TRI-LAKES MONUMENT FIRE PROTECTION DISTRICT

February 8, 2018

El Paso County Development Review
Attention: Raimere Fitzpatrick
File Number: EA-17-109

Applicant: Forest Lakes Phase II PUD

PHASE 2 OVERALL

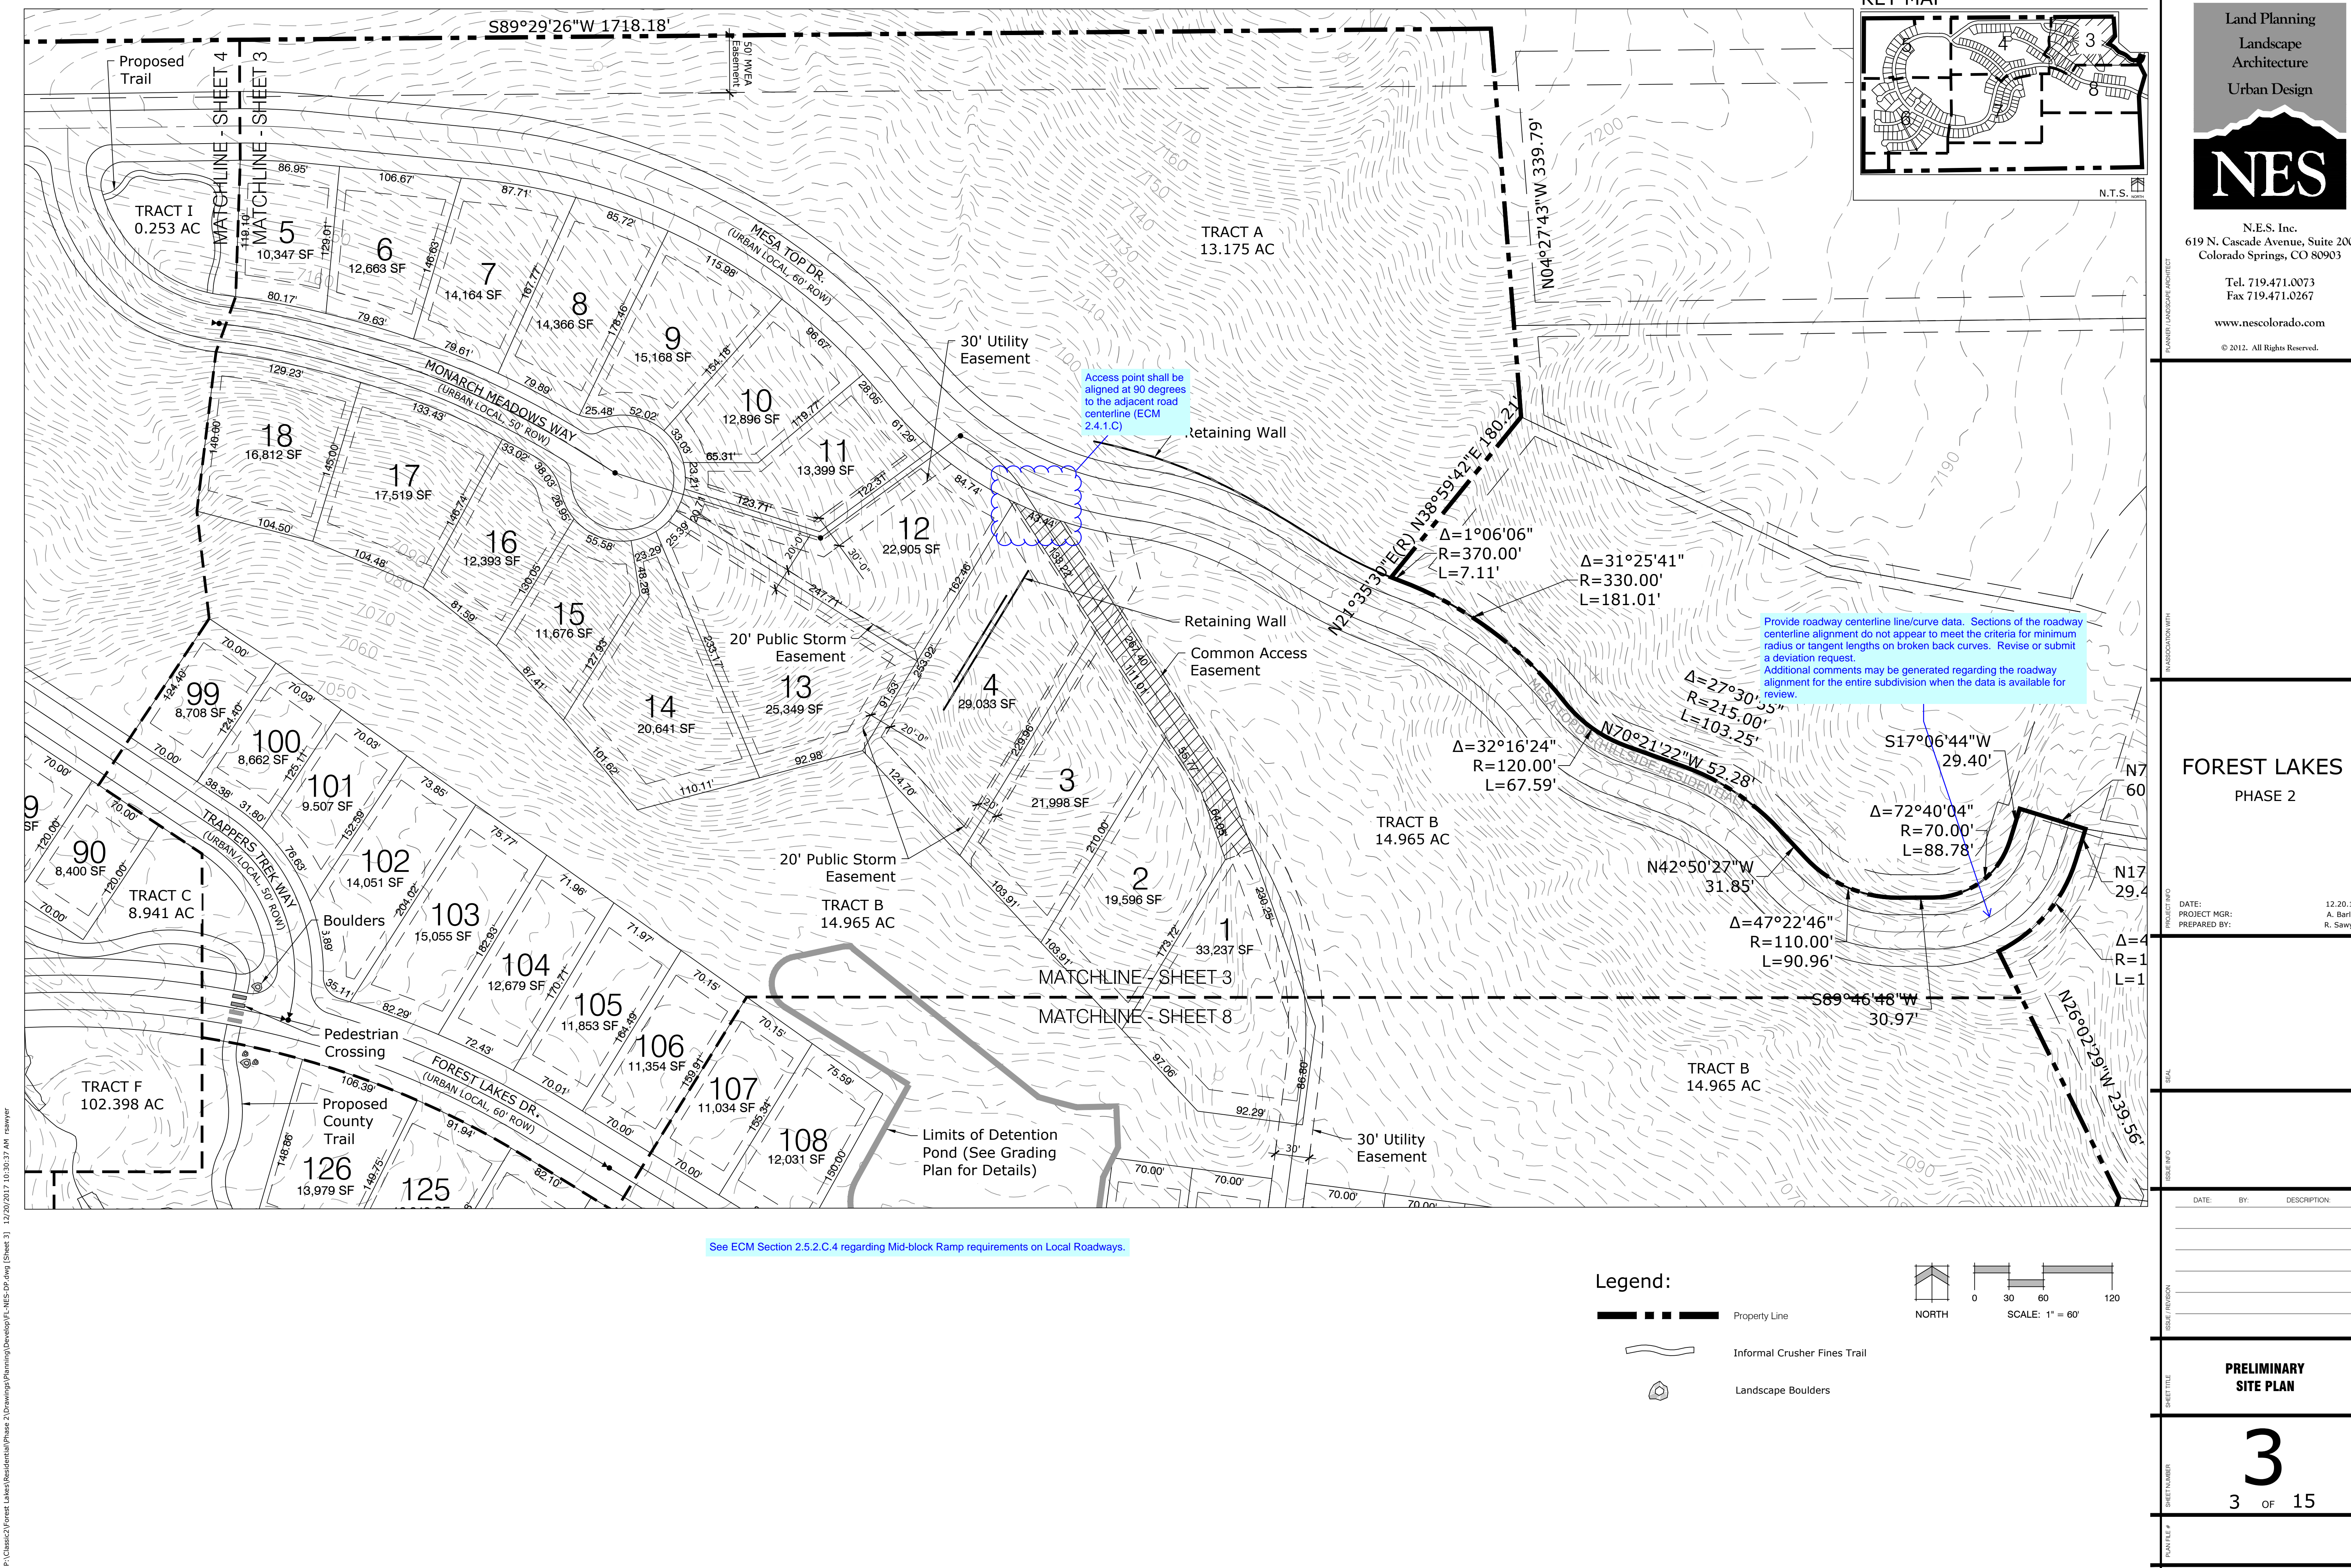
- The subdivision currently only has one exit from the east (Forest Lakes Drive via Baptist Road), and it appears to be an additional exit to the north (via Lindbergh Drive). The 2012 International Wildland Urban Interface Code, states that exits should be of sufficient size to accommodate both the exiting/evacuating residents along with access for first responders simultaneously. With 503 homes being built in the first two phases and an additional 61 in Phase III we require that there be at least two exits for safely evacuating residents during emergencies and would recommend a third exit.
- Otherwise the proposed design appears to meet the minimum requirements established by the International Fire Code-2009 (IFC-09) and the TLMFPD Local Amendments to the IFC-09.
